Arun District Council
Arun Civic Centre
Maltravers Road
Littlehampton
West Sussex BN17 5LF
Planning & Building Control General Enquiries
Tel: (01903) 737756 Fax: (01903) 730442
Dx: 57406 Littlehampton
Minicom: 01903 732765
e-mail: planning@arun.gov.uk
website: www.arun.gov.uk/planning

Application No: AB/88/21/HH
Site Address: 55 Fitzalan Road Arundel BN18 9JP
Description of works: Single storey rear extension. First floor extensions replacing hipped roof with flat roof. Porch to front

Thank you for your internet representation made on 9th August 2021 which has been recorded as an objection with the comments as follows:

Proposed Extension and Loft Conversion
at 55 Fitzalan Road, Arundel
for Mr R Dowson & Ms S Harnett
Drawing P02 June 2021 Scale 1:100 / 1:500 @ A3
Planning Drawing - Roof Plan, Elevations & Block Plan

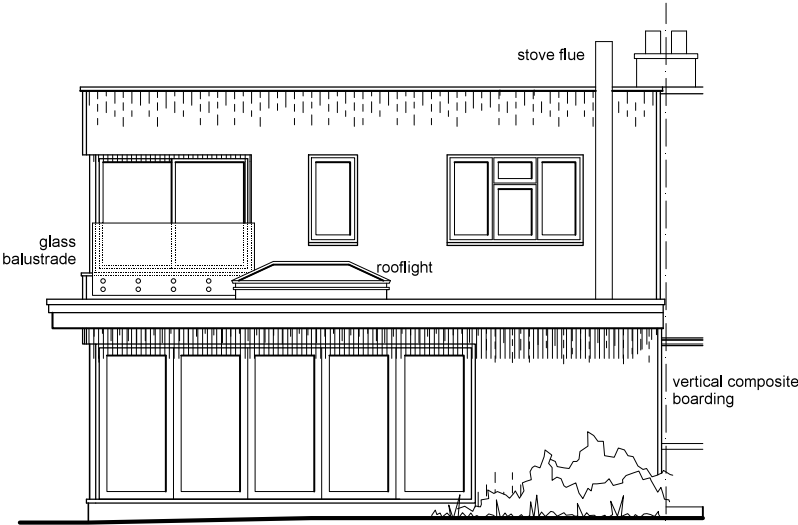
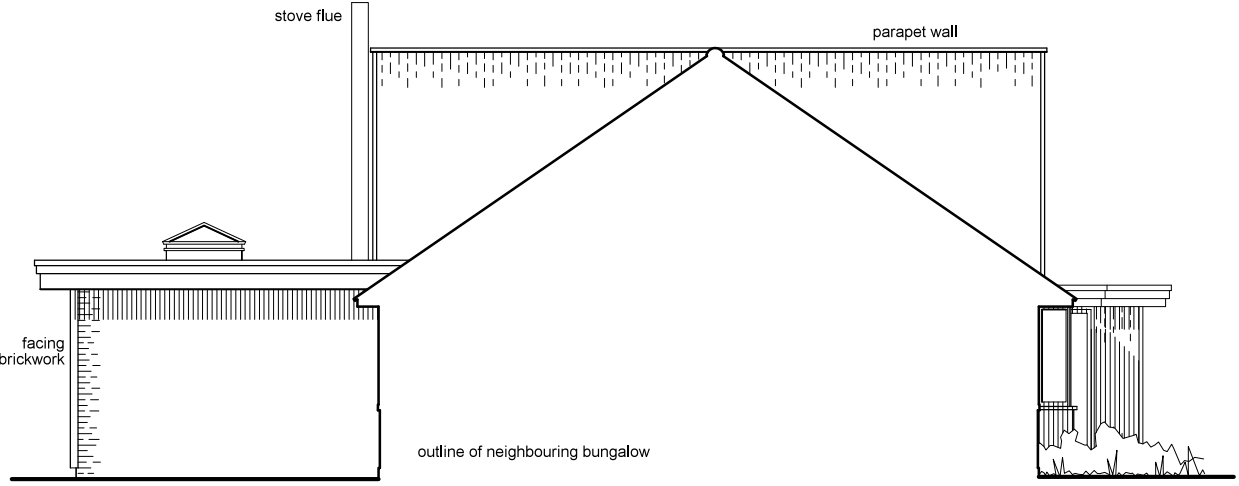
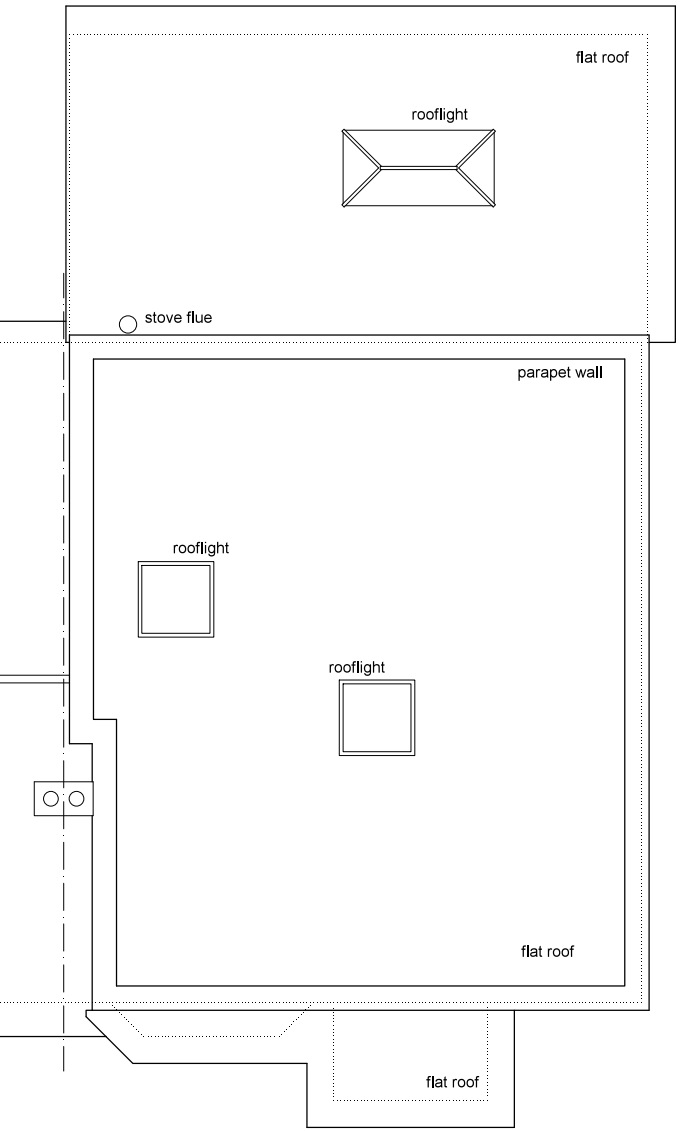
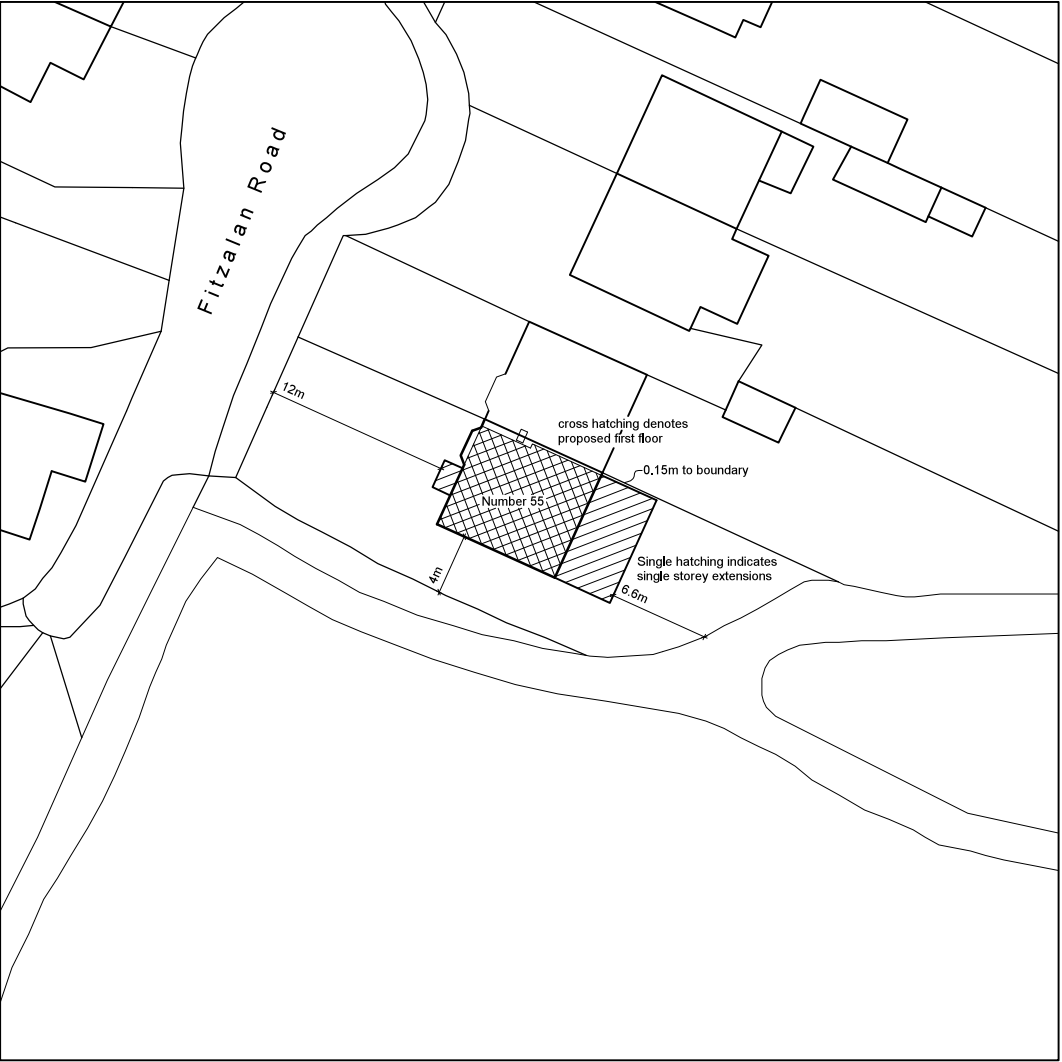
The Committee objected to the Application on the grounds that it is contrary to the Arundel Village Design Statement, Arun Design Guide and Arun Local Plan Policy DM4. The proposal is wholly unsympathetic to the existing building and its form does not relate to the existing building, has an overbearing effect on its neighbour, and is not a positive addition to its locale.
